From:
Sent: 05 September 2026 14:40
To: DC Admin
Subject: Objection to Planning Application 2026/62/91926/E - 158 Hawthorne Way Shelley

Planning has recently been granted for 156 Hawthorne Way (ref. 2025/93035, dated 10/03/2026, Responding Officer D. Stainsby, Ref K12-41/4), for a garage extension and conversion to part living space. However, the use of the service strip as parking in this plan was refused.

PROPOSED MATERIALS	
• DOORS	— ALUMINIUM BI-FOLDS

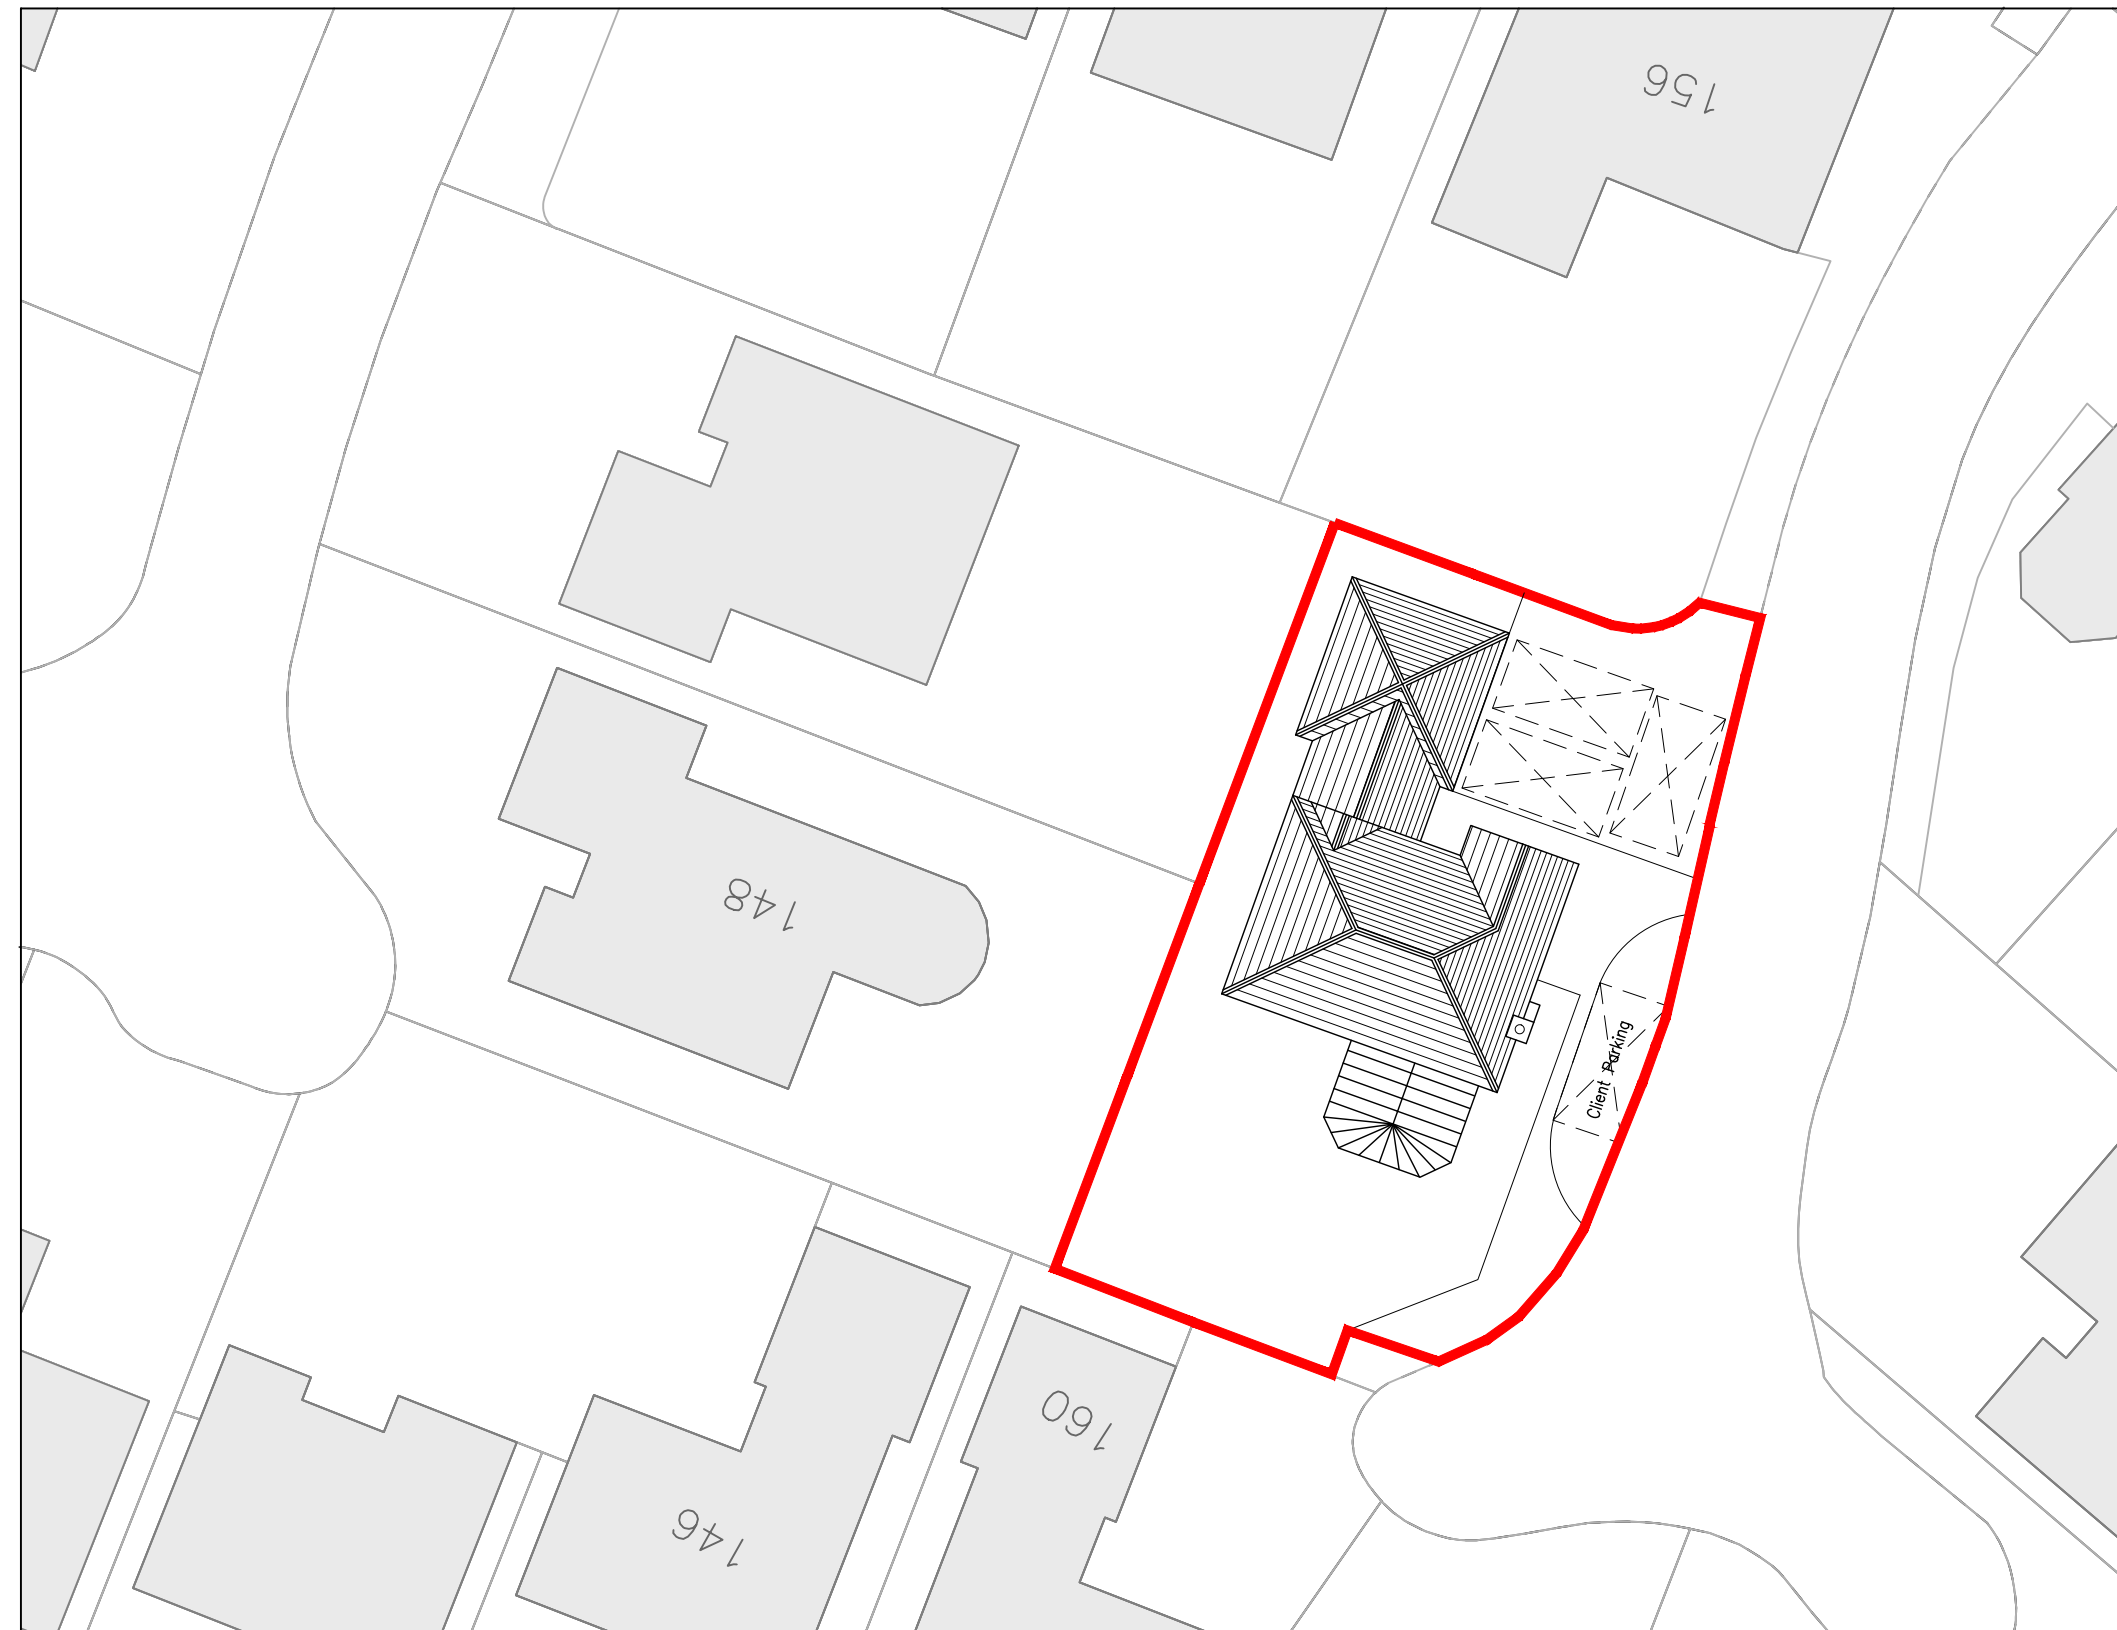
I am writing with further information concerning my objection to the above planning application.
I wish to submit supplementary evidence in support of the points I raised regarding parking provision and the highway-service strip ownership

As a result, there is not sufficient width to provide a parking space as proposed within the curtilage of the property at this location and Highways D.M cannot support the application as submitted

I feel this is also applicable to the proposed plans for 158 Hawthorne Way and that Highways should be consulted as to the status, use and ownership of said 1.8 metre service strip.
